**Consultation Response from: KC Environmental Health (Pollution & Noise Control)**
**2025/91737 - 70-84 Sheepridge Road, Sheepridge, Huddersfield, HD2 1HG**
**Change of use of the land to mixed use as carwash and tyre sales, repair and fitting including associated buildings, creation of new access, parking and works.**
**Responding Date:  
08 January 2026**
**Responding Officer:  
Mohammed Nasim**
**Responding Ref:  
WK202540215**
**Comments**

Figure 7
Tyre Servicing Area relocated

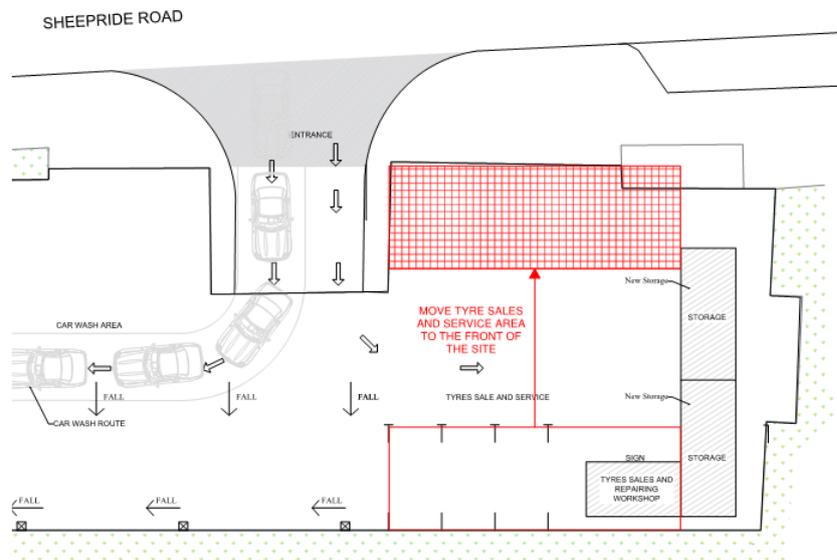
Recommendations are made for a 2m high barrier to be installed as shown in figure 10 along with the re-siting of the tyre servicing area as shown in figure 7 and the report proceeds to consider the relevant noise sources specifically, the use of the jet wash, hoover, impact gun and tyre changer.
